DEPARTMENT OF PUBLIC WORKS

MEMORANDUM

SUBJECT: Nowak Short Plat SP-10-00009

The following shall be conditions of preliminary approval:

*NOWAK*  
**ALEXANDER SHORT PLAT**  
WITHIN THE SW 1/4 SECTION 3 T18N R18EW  
KITITAS COUNTY WA.

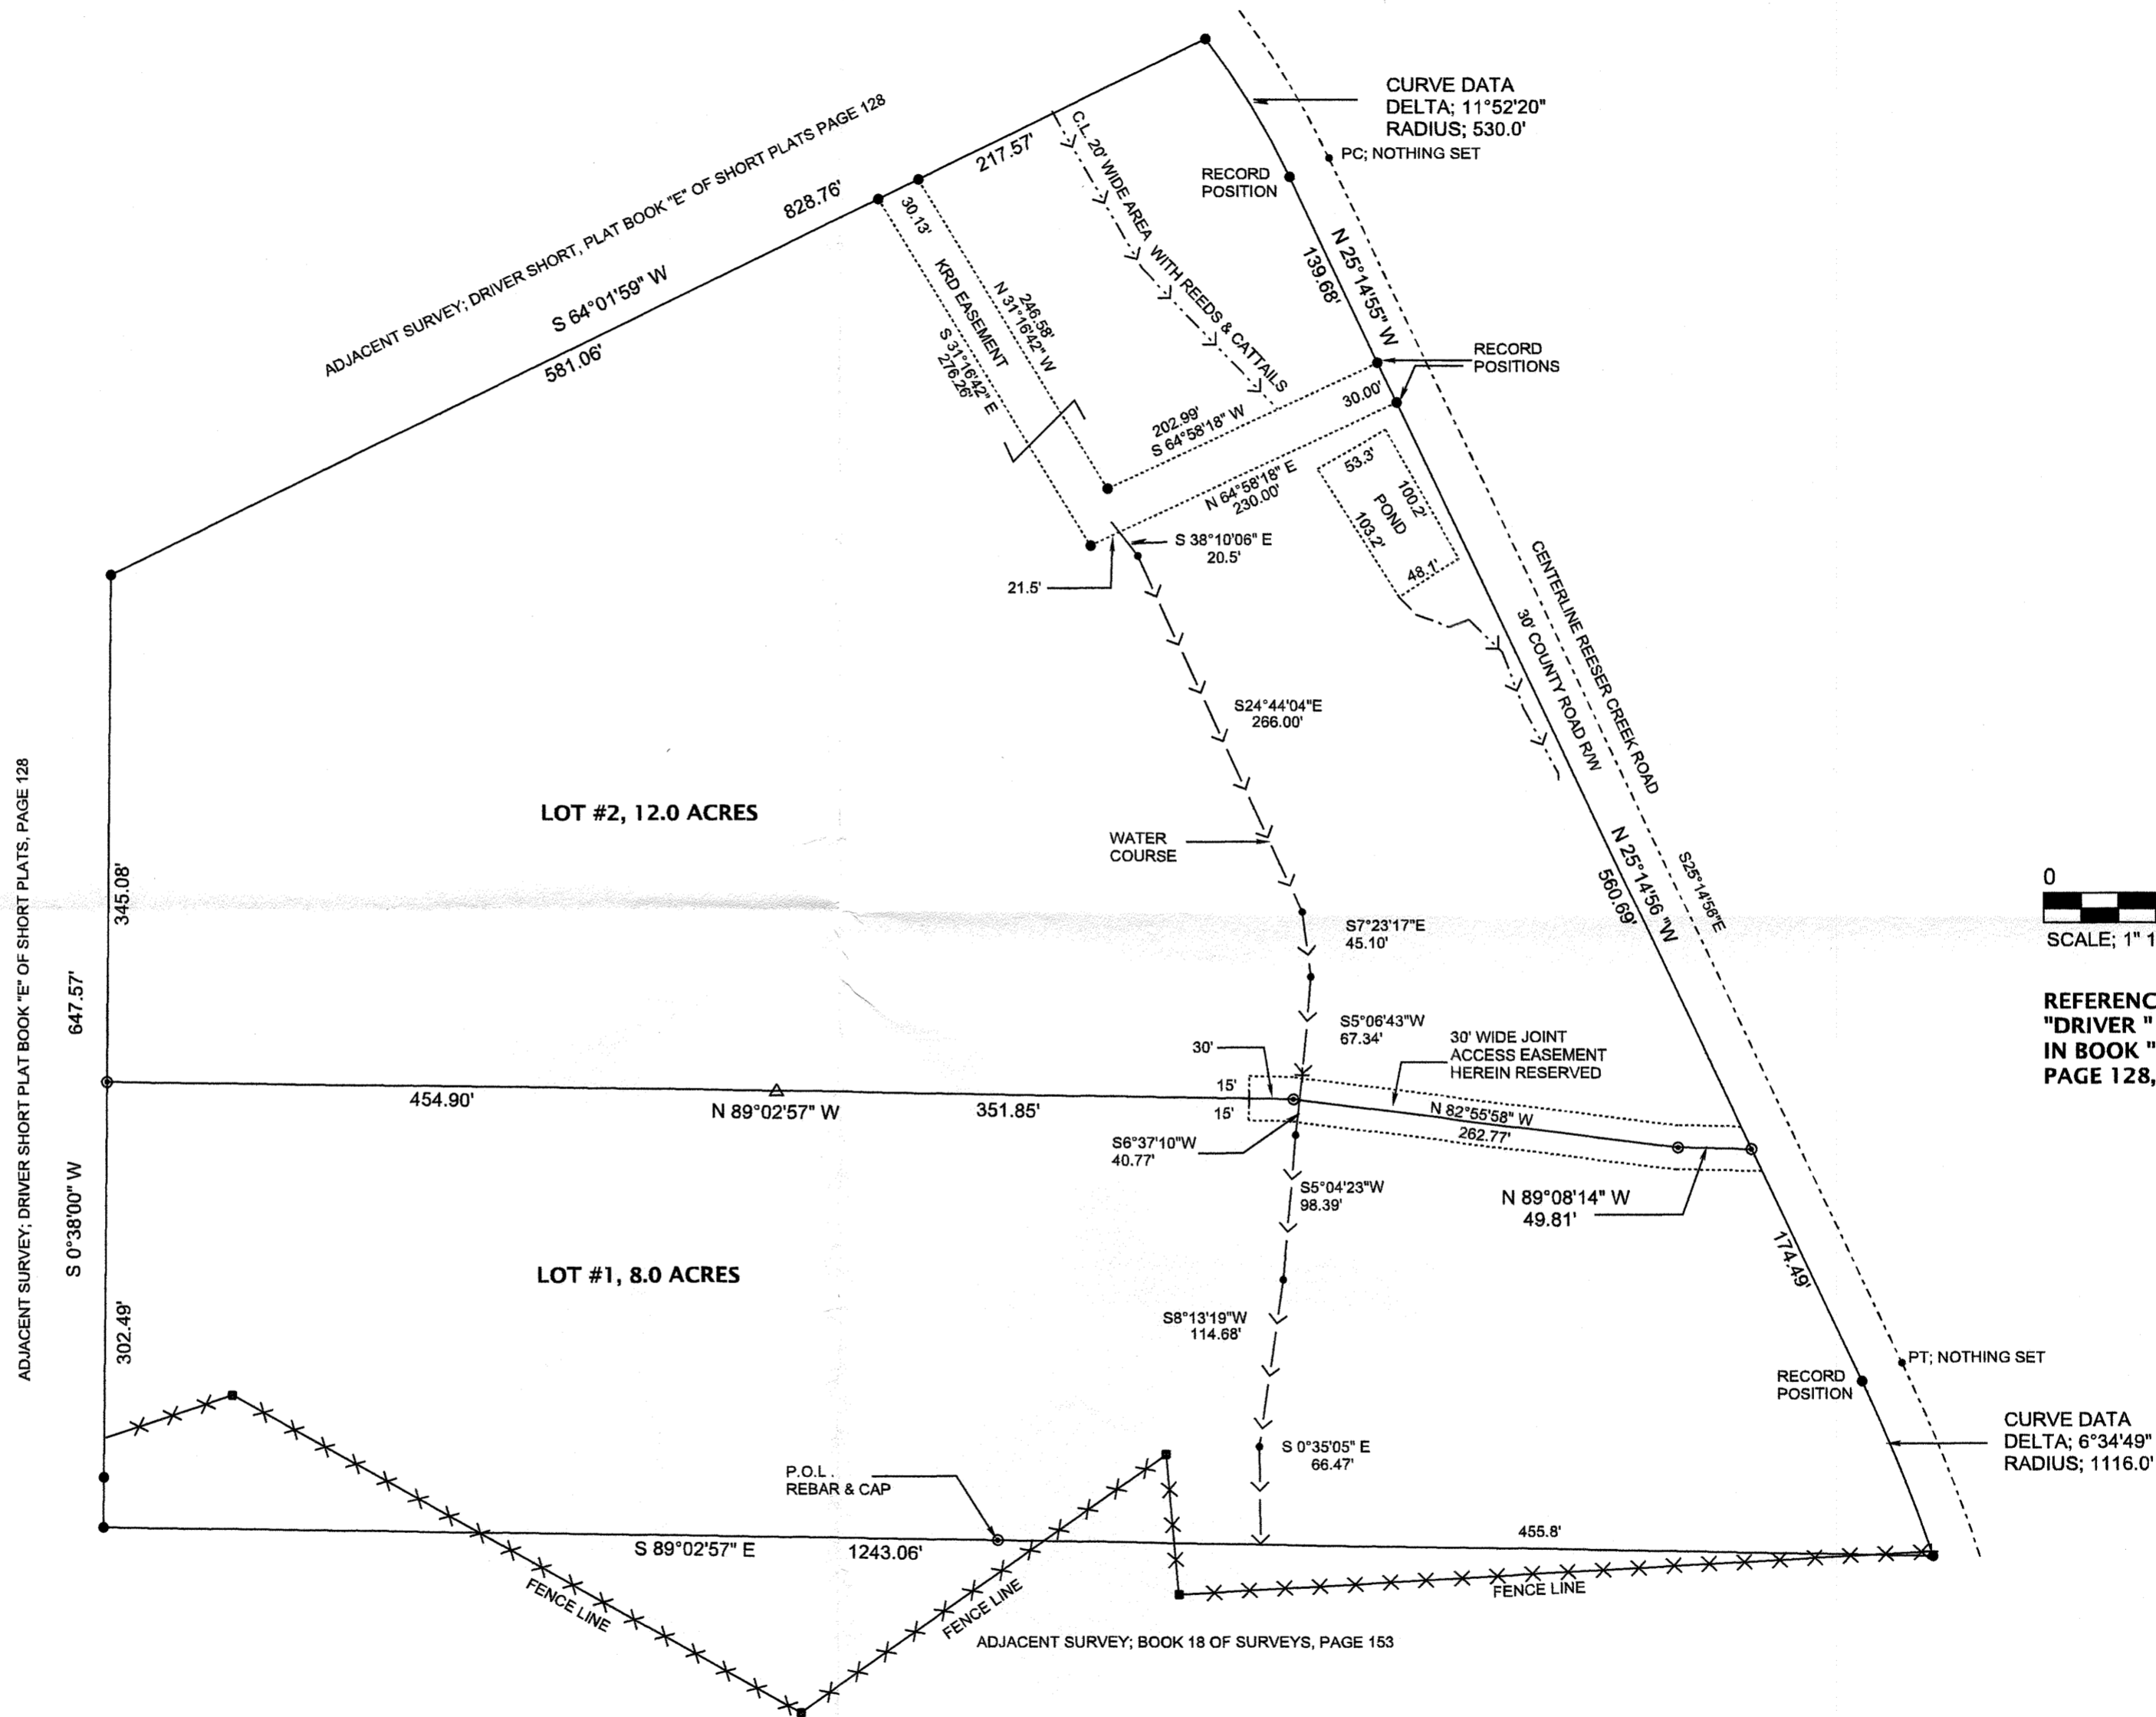
1. County Road Approaches: The access permit for the approach at 8621 Reecer Creek Road has expired (2007-0226). A new access permit application must be submitted in order to allow continued use of the approach. The new approach near the northeast corner is unpermitted and illegal, and an access permit application shall also be submitted for this approach. Current standards will be applied to both permits, which may require improvements to the approaches.

2. Joint-Use Driveway: A joint-use access shall serve no more than two tax parcels. See Kittitas County Road Standards, 9/6/05 edition.
 - a. Access easements shall be a minimum of 20' wide. The roadway width shall have a minimum width of 12'.

- b. The surface requirement is for a minimum gravel surface depth of 6".
 - c. Maintenance of driveway approaches shall be the responsibility of the owner whose property they serve. The County will not maintain accesses.

*NOWAK*  
**ALEXANDER SHORT PLAT**  
**WITHIN THE SW 1/4 SECTION 3 T18N R18EWM**  
**KITTITAS COUNTY WA**

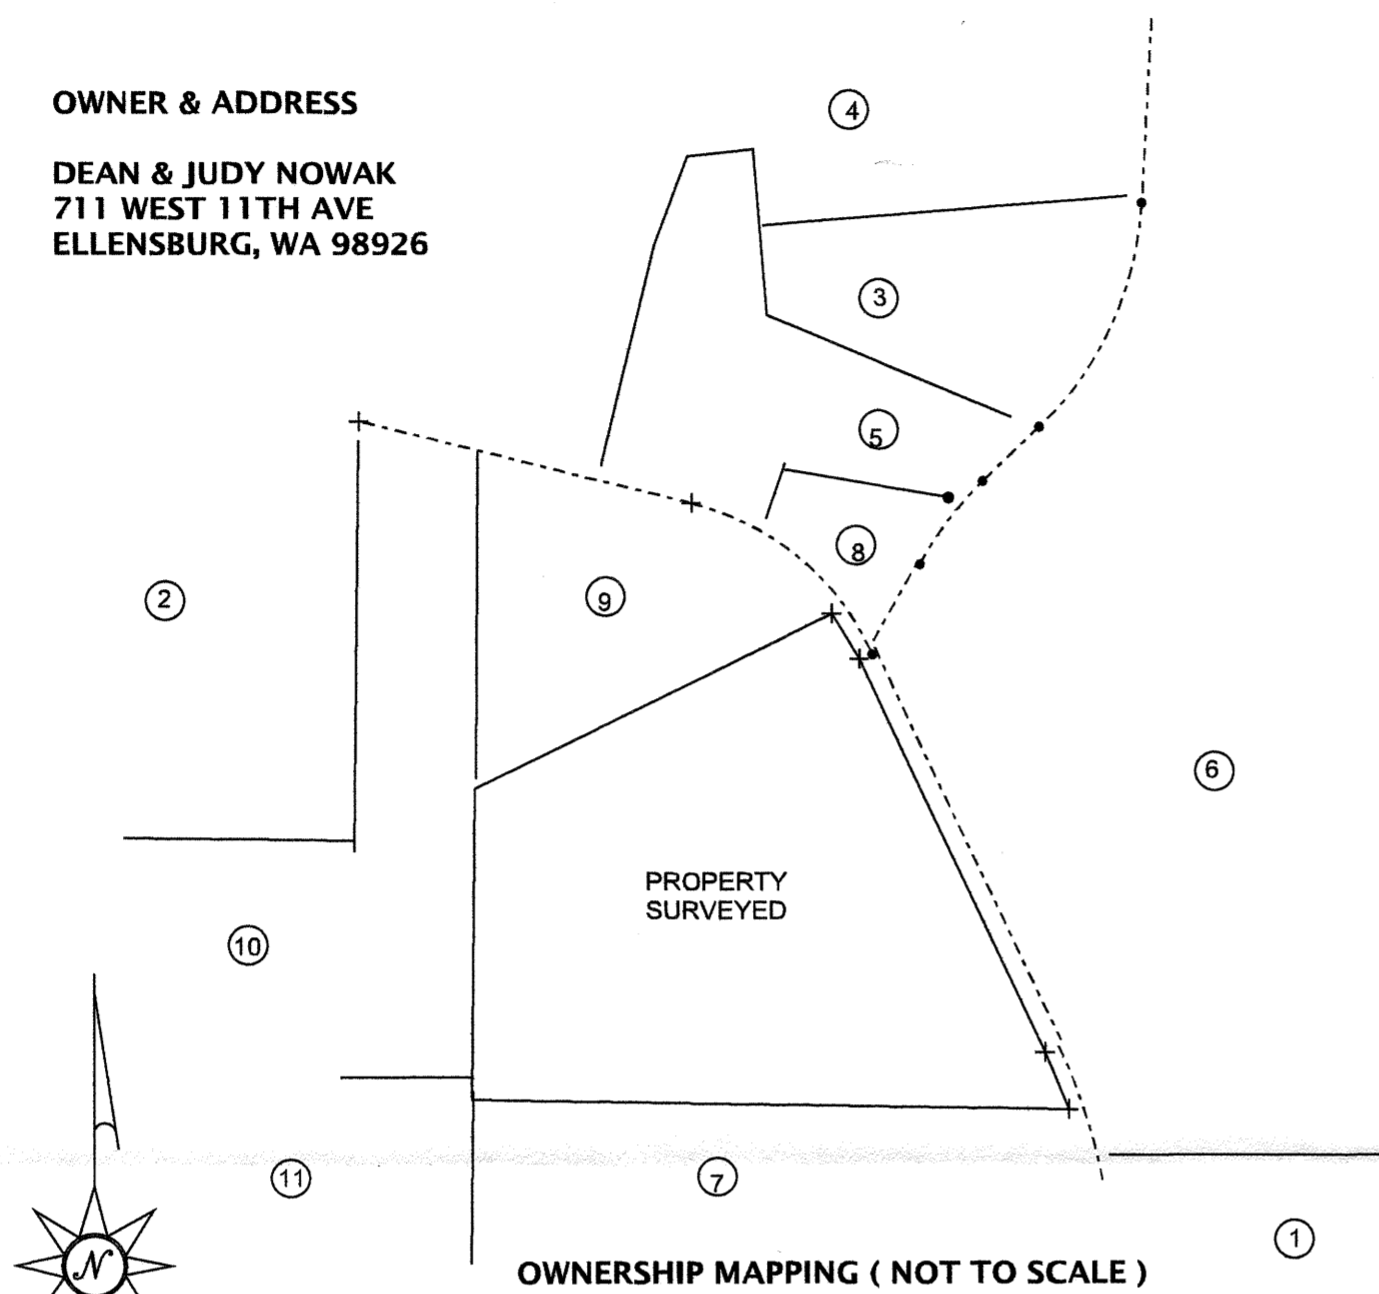
- d. Any further subdivision or lots to be served by proposed access may result in further access requirements.
3. Plat Notes: Plat notes shall reflect the following:

- a. Maintenance of the access is the responsibility of the property owners who benefit from its use.
 - b. An approved access permit will be required from the Department of Public Works prior to creating any new driveway access or performing work within the county road right of way.

- c. Any further subdivision or lots to be served by proposed access may result in further access requirements. See Kittitas County Road Standards.

- d. A public utility easement 10 feet in width is reserved along all lot lines. The 10 foot easement shall abut the exterior plat boundary and shall be divided 5 feet on each side of interior lot lines. Said easement shall also be used for irrigation.
4. Plat Approvals: All plats must show the acceptance signature of the County Engineer. The acceptance block shall be as follows (per KCC 16.24.170):
